NORTH FALLS OFFSHORE WIND FARM

Appendix G4.3 to the Natural England Deadline 4 Submission
Natural England's Kittiwake Compensation Advice on the Applicant's Deadlines 1 and 2 Documents

Planning Inspectorate Reference EN010119

25 April 2025

Location of Kittiwakery and Saltmeadows ANS

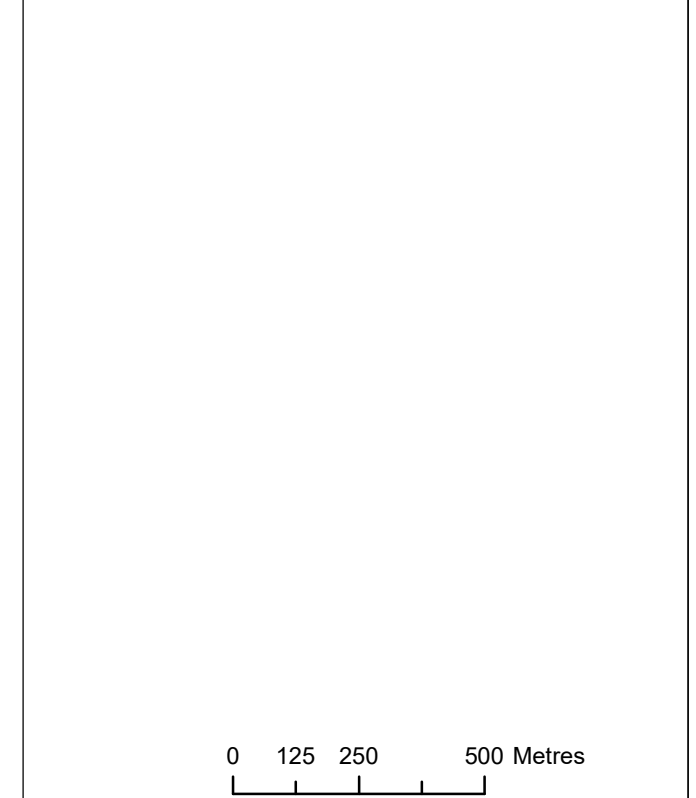
Natural England request further clarity on how this is to be achieved, in principle, at a shared ANS with relatively limited capacity. Furthermore, consideration should be given to the apportioning of benefits arising at the structure. It is our understanding that Five Estuaries OWF are attempting to secure a share in the ANS equivalent to approximately 48 nesting spaces (Five Estuaries Examination Document REP5-018) for a broadly similar impact. It remains unclear that a contribution in line with the required scale of implementation is possible or proposed by the Applicant. However, it does appear likely that the Applicant is investigating an option that should result in there being sufficient breeding pairs to compensate their CIV, assuming that the ANS is sufficiently colonised.

Natural England highlight that while the ANS has already been built, which gives comfort around lead-in times, it remains unclear exactly how the Applicant intends to utilise and share the ANS with other interested parties, and if there is sufficient space to satisfy the total requirement. We are keen to understand from the Applicant whether they will be taking a similar approach to Rampion 2 and Five Estuaries in securing a specific share of nest spaces on the 'kittiwakery'.
